Martin Nugent
01254 828060
D3/11/0548

Drafted 7 October 2011

**Planning Application, Ribble Valley District
D3-11-0548 18 Whalley Road, Clitheroe**

18 Whalley Rd

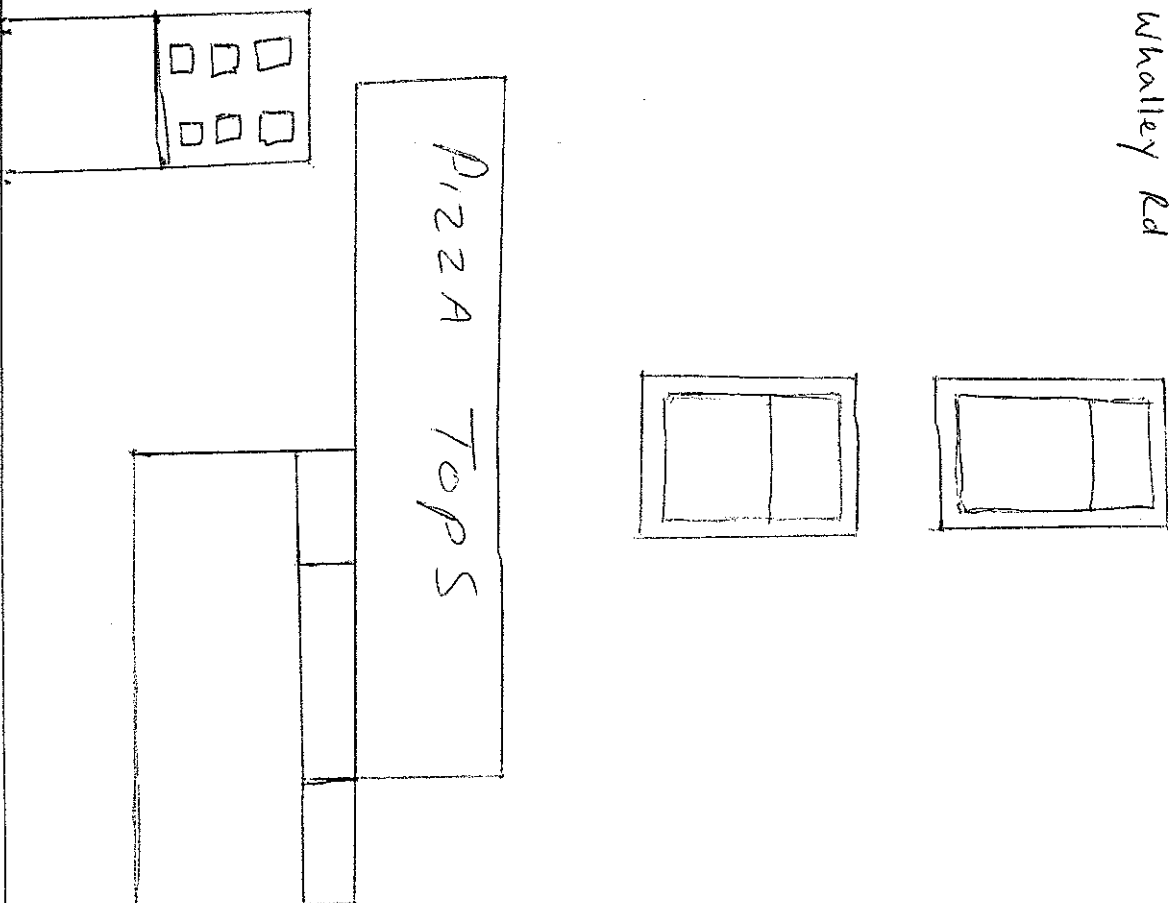
The one clarification I will attach to this application concerns the mounting height of the proposed sign. The drawing provided indicates, incorrectly, that the height of the sign is 3.2m to the top of the sign. The mounting height must be 3.2m from the footway level to the base of the sign.
